Appendix Q-1 – Details of Refinements to the Proposed Scheme – Refinements to the Extents of the Application Site

Great Yarmouth Third River Crossing
Further Consultation Design Changes
Area 1: Suffolk Road Red Line Boundary Changes

SURVEYED BY	INITIAL	DATE	DRAWING No.
DESIGNED BY	KP	02/19	PKA018-MP-098
DRAWN BY	KP	02/19	PROJECT TITLE
CHECKED BY	GB	02/19	Great Yarmouth Third River Crossing
			SCALE
			NTS
			FILE No.
			PKA018

DRAWING TITLE
 Great Yarmouth Third River Crossing
 Further Consultation Area of Consultation
 Area 1: Suffolk Road Red Line Boundary Changes

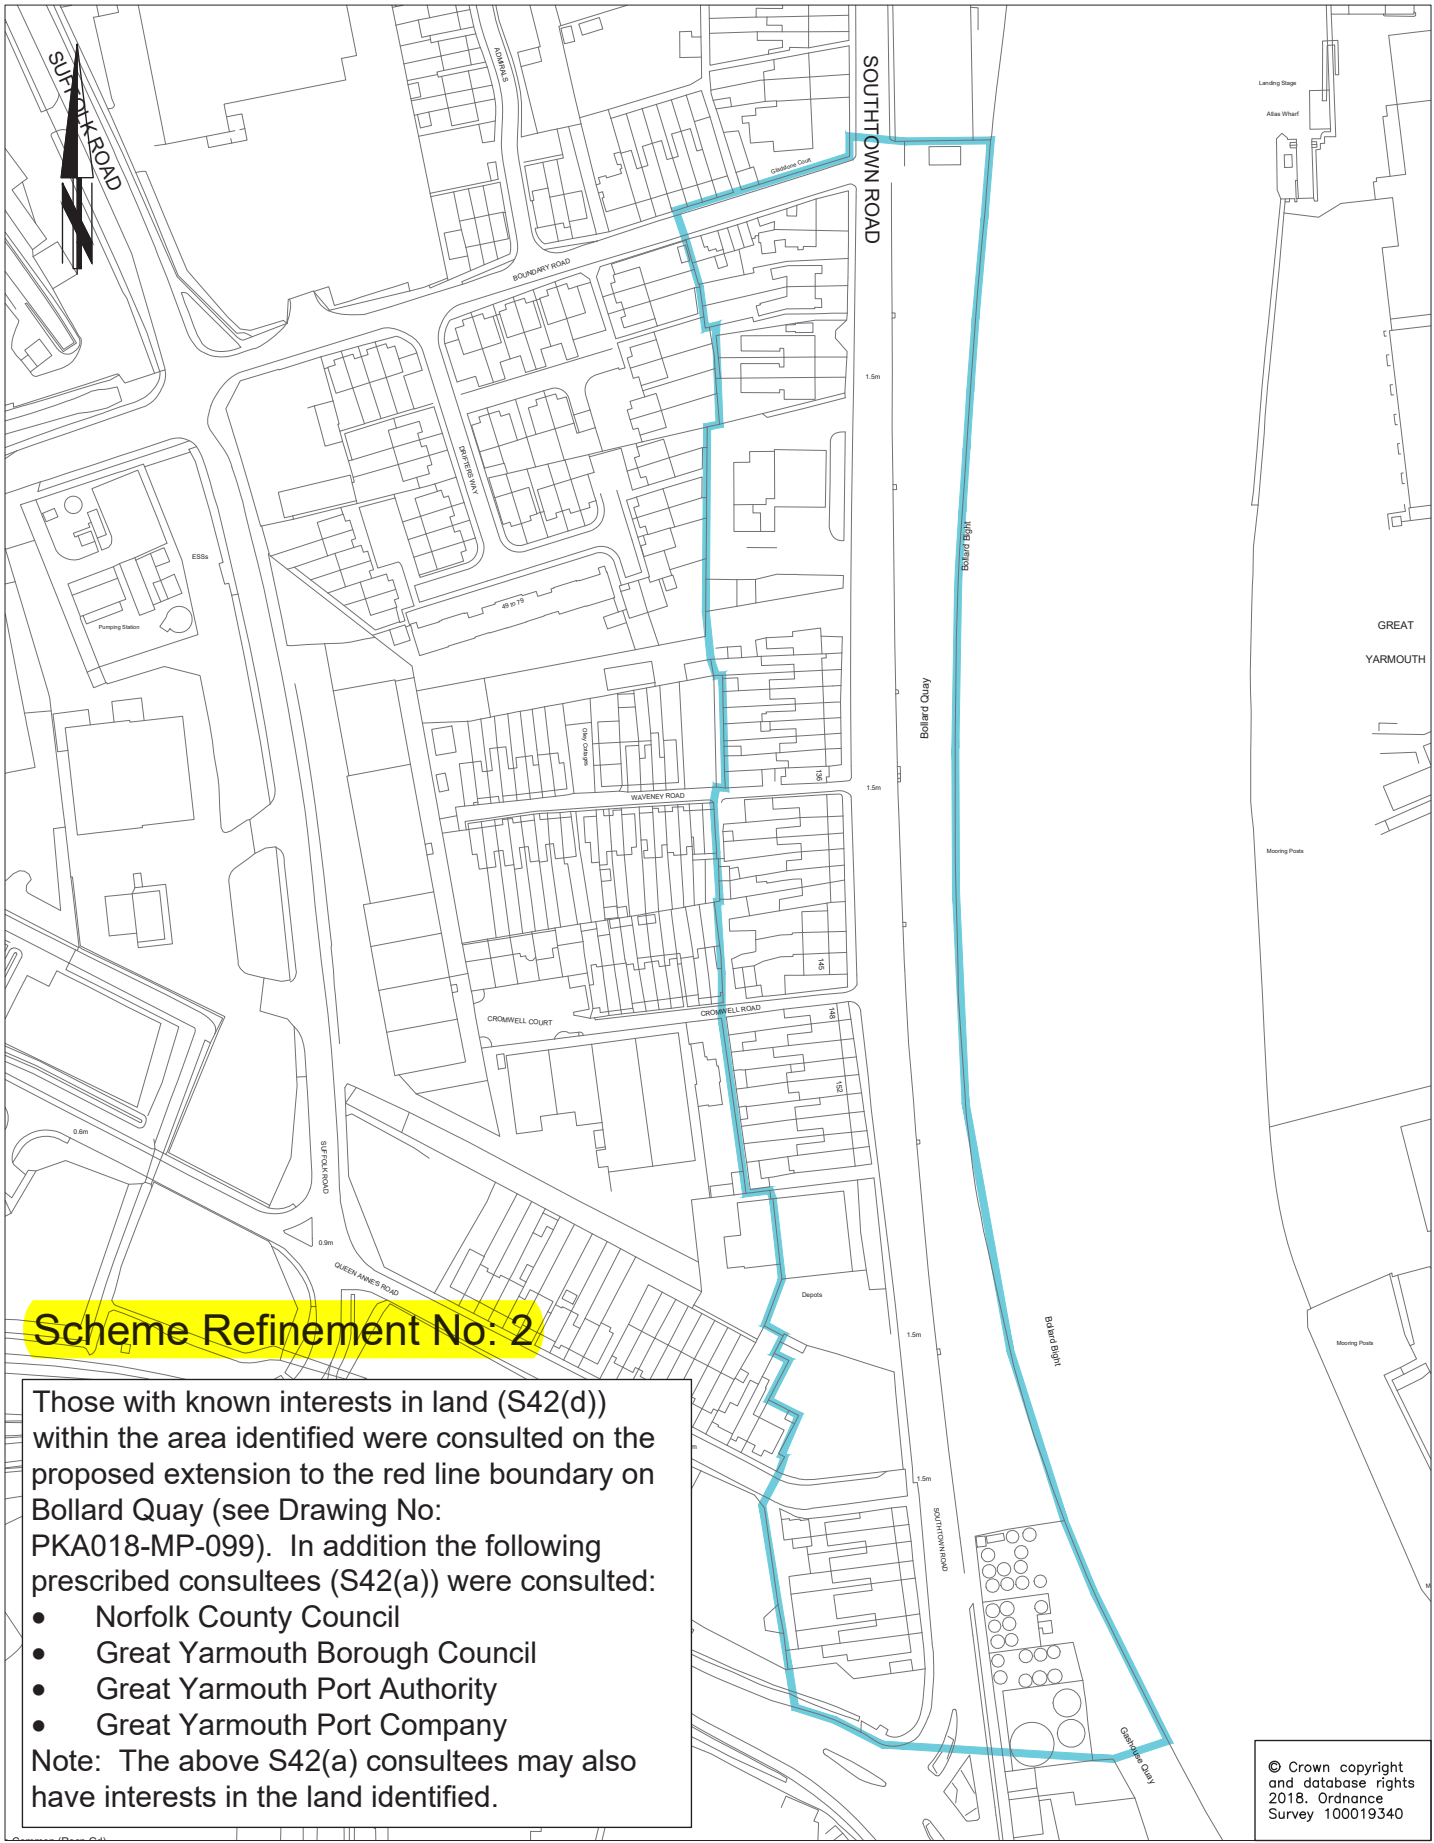
Proposed extension to the red line boundary on Suffolk Road northwards so that it includes the Suffolk Road/Boundary Road junction.

To allow for any potential temporary changes to the junction that may be required during construction of the Scheme in order to maintain access to Suffolk Road.

DRAWING TITLE
 Great Yarmouth Third River Crossing
 Further Consultation Area of Consultation
 Area 2: Bollard Quay Red Line Boundary Changes

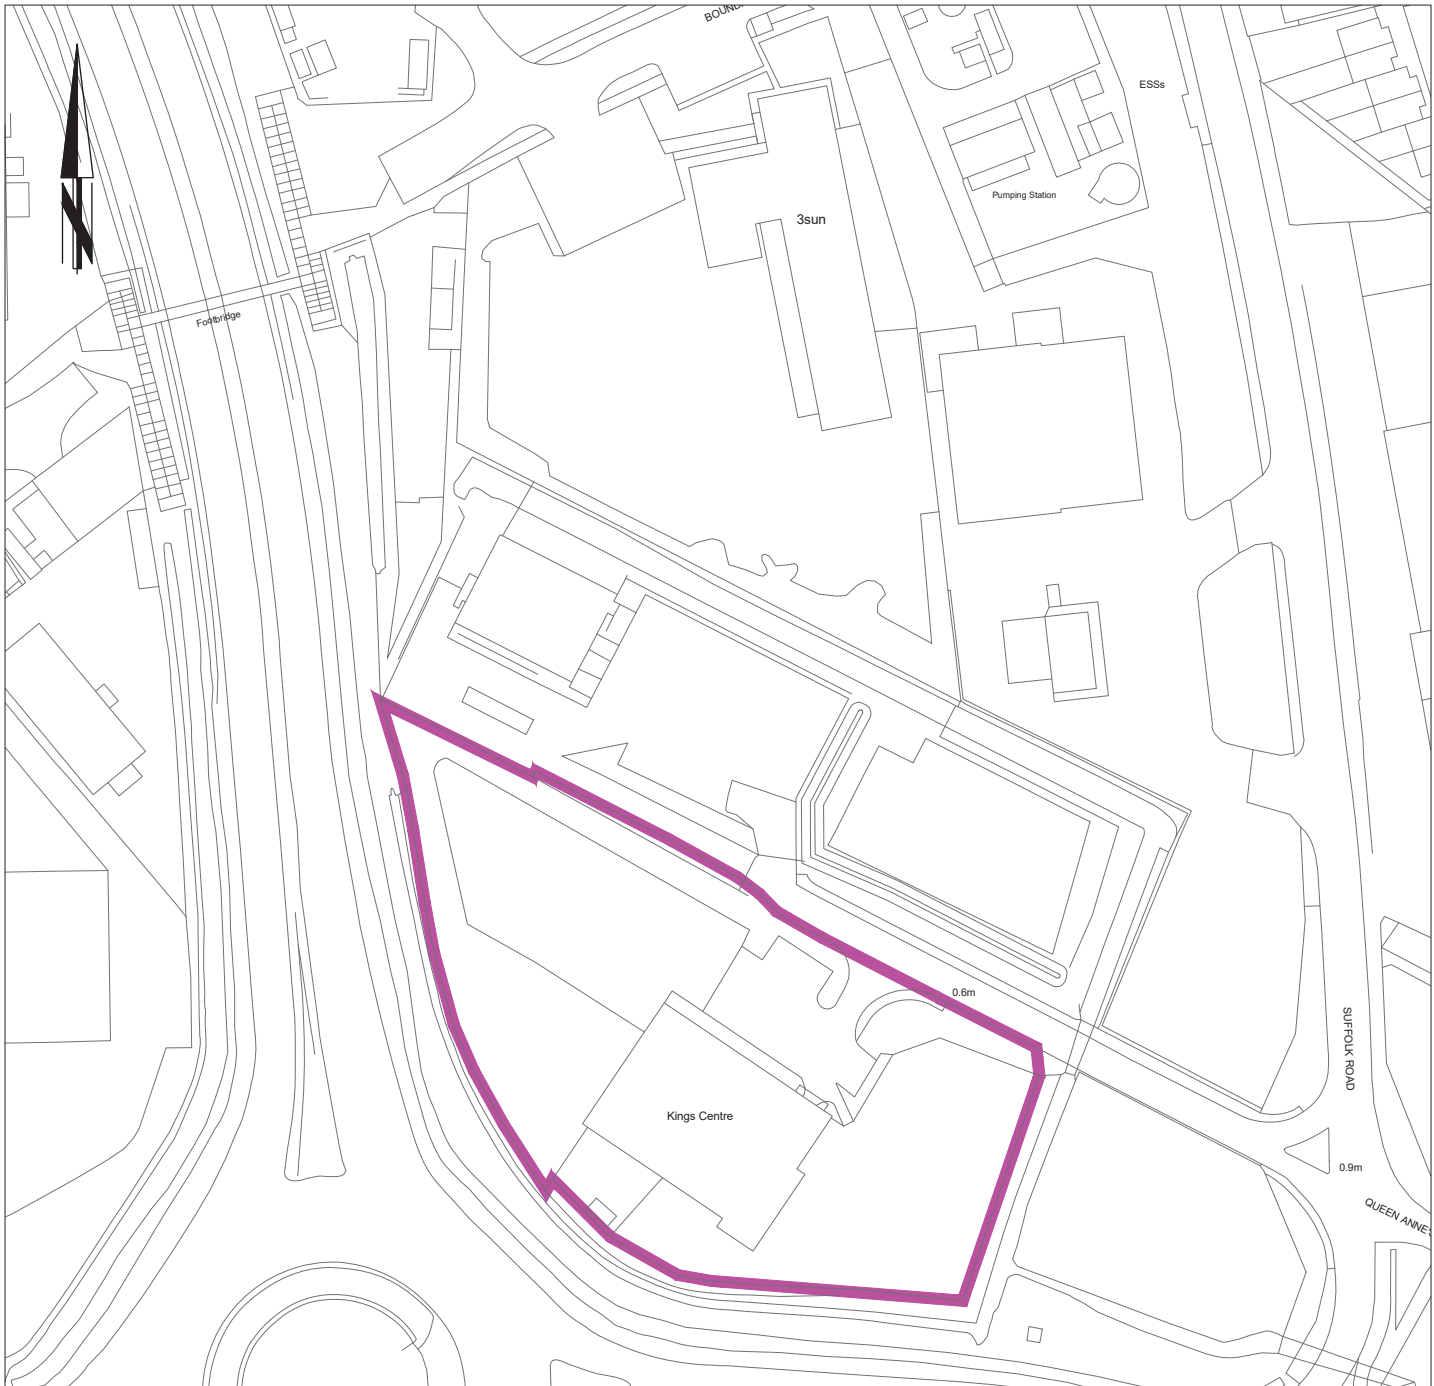
Proposed extension to the red line boundary on Bollard Quay northwards to its northern boundary and southwards to its southern boundary.

To allow construction vehicles to use the existing access ramps to and from Bollard Quay during construction therefore removing the need to construct a separate temporary access.

DRAWING TITLE
 Great Yarmouth Third River Crossing
 Further Consultation Area of Consultation
 Area 3: Kings Centre Red Line Boundary Changes

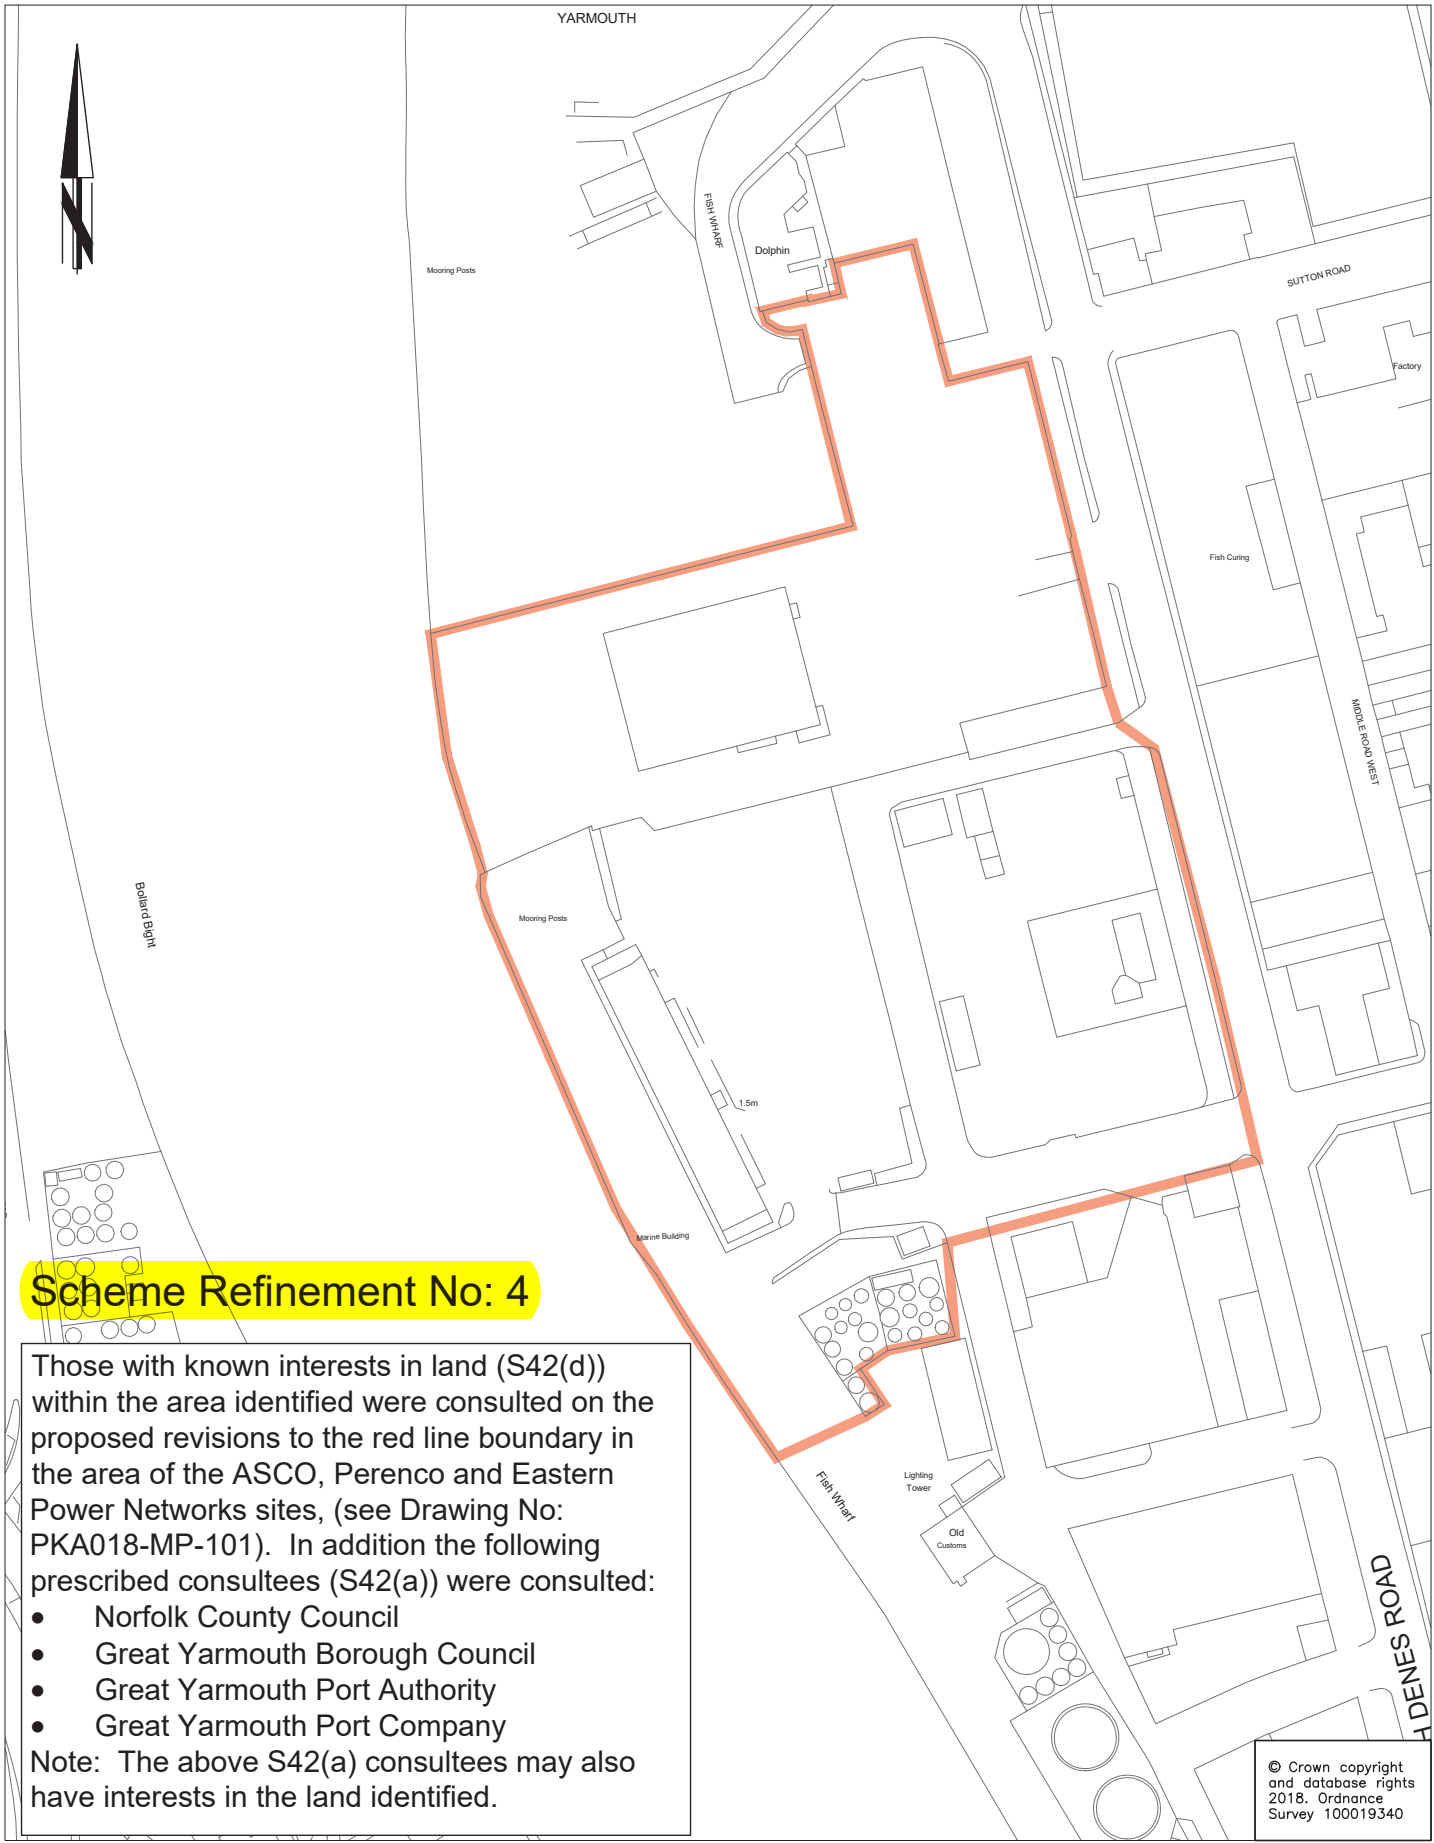
Proposed revisions to the red line boundary in the area of the King Centre, which results in areas of land no longer being within the Scheme boundary.

As the Scheme has been developed these areas of land have been identified as being no longer required for the permanent scheme or required temporarily during construction.

DRAWING TITLE
 Great Yarmouth Third River Crossing
 Further Consultation Area of Consultation
 Area 4: ASCO/Perenco Red Line Boundary Changes

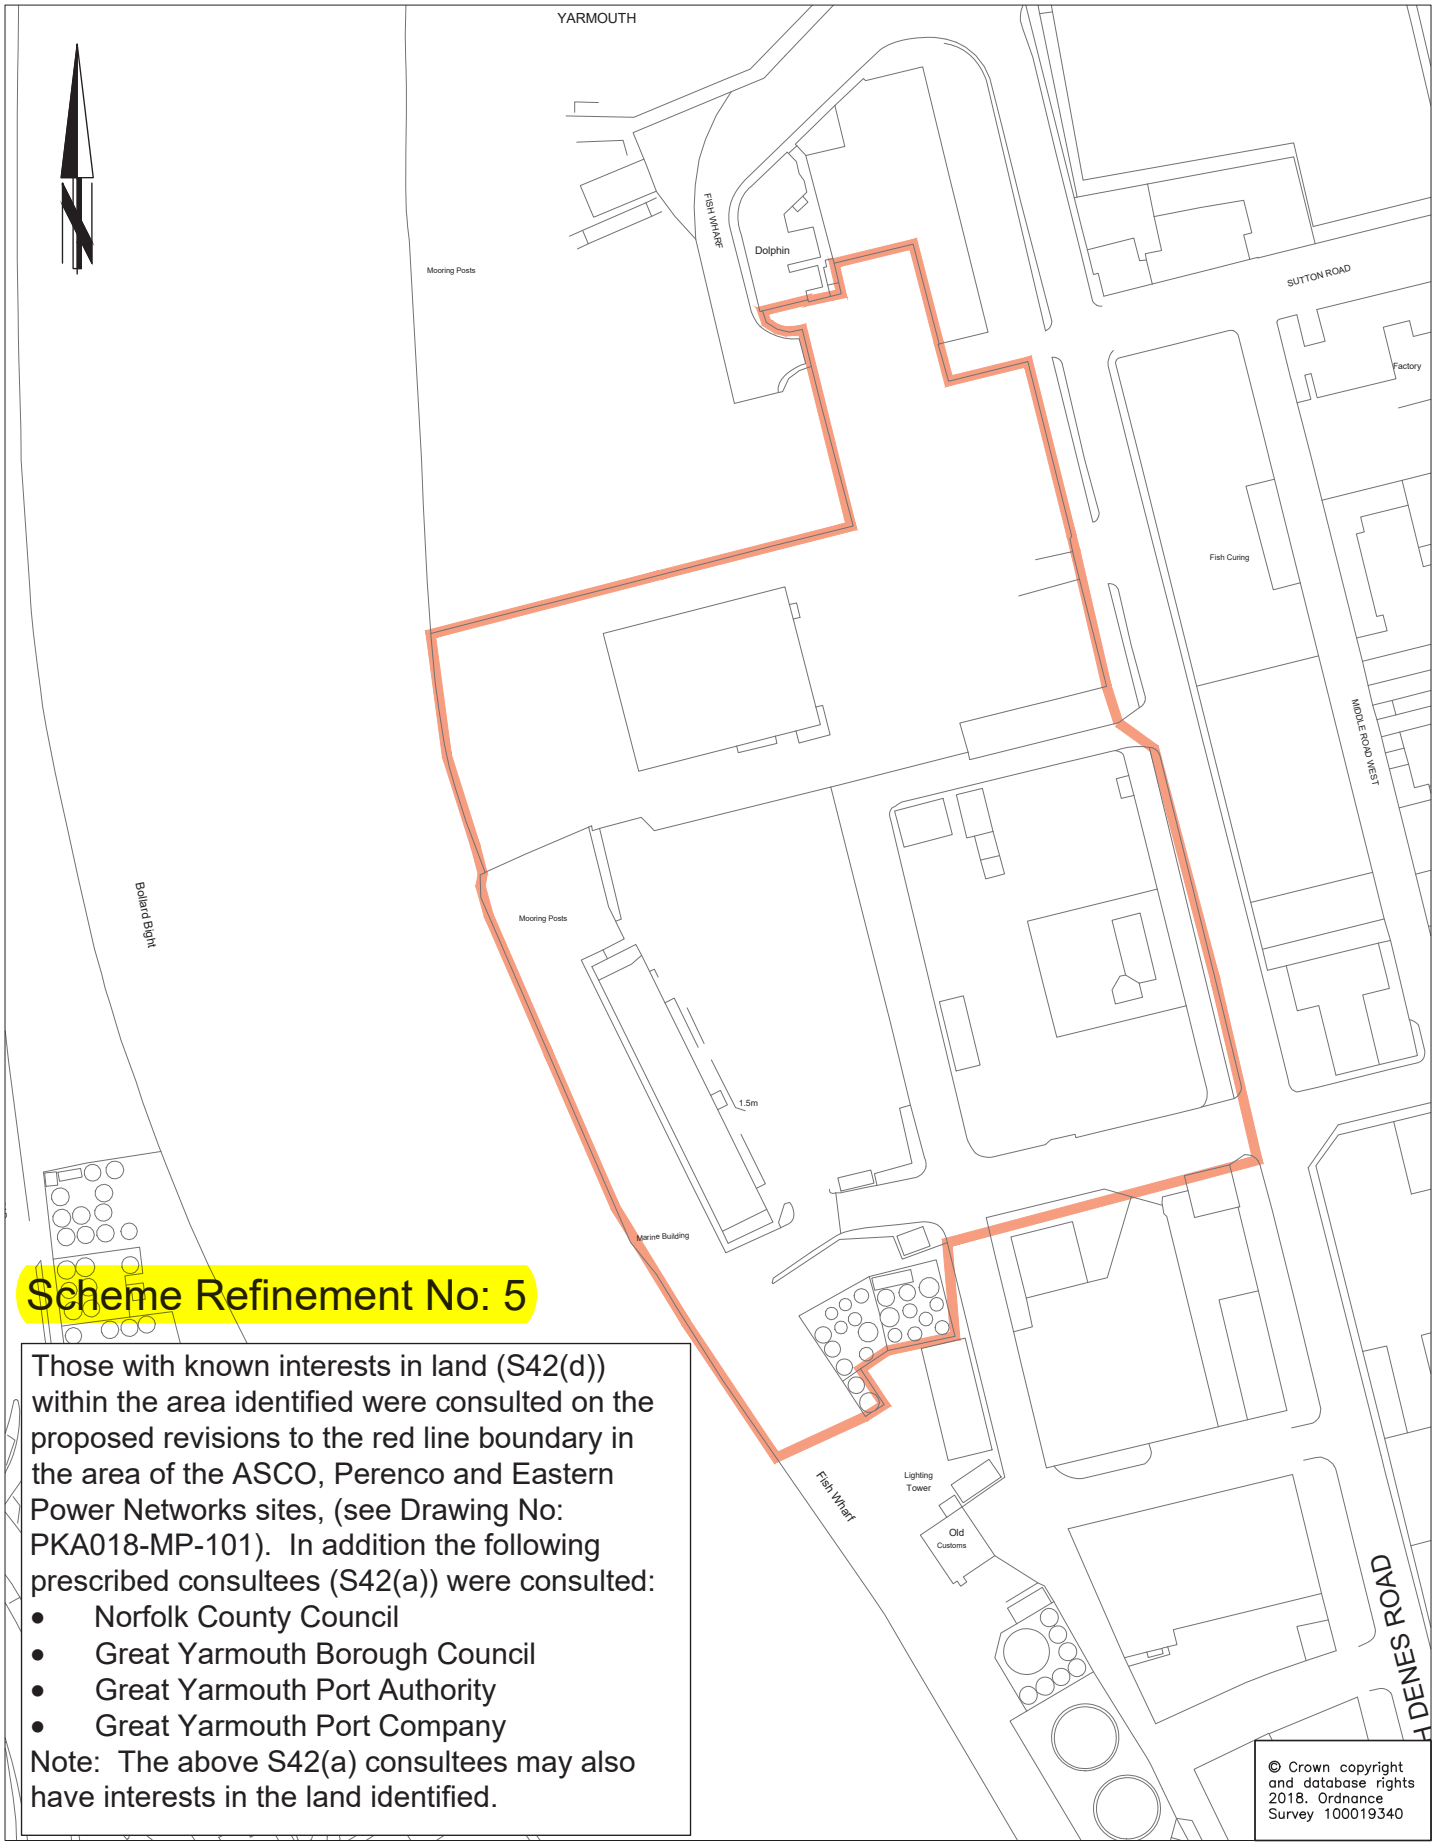
Proposed revisions to the red line boundary in the area of the ASCO, Perenco and Eastern Power Networks sites, which results in areas of land no longer being within the boundary.

As the Scheme has been developed these areas of land have been identified as being no longer required for the permanent scheme or required temporarily during construction.
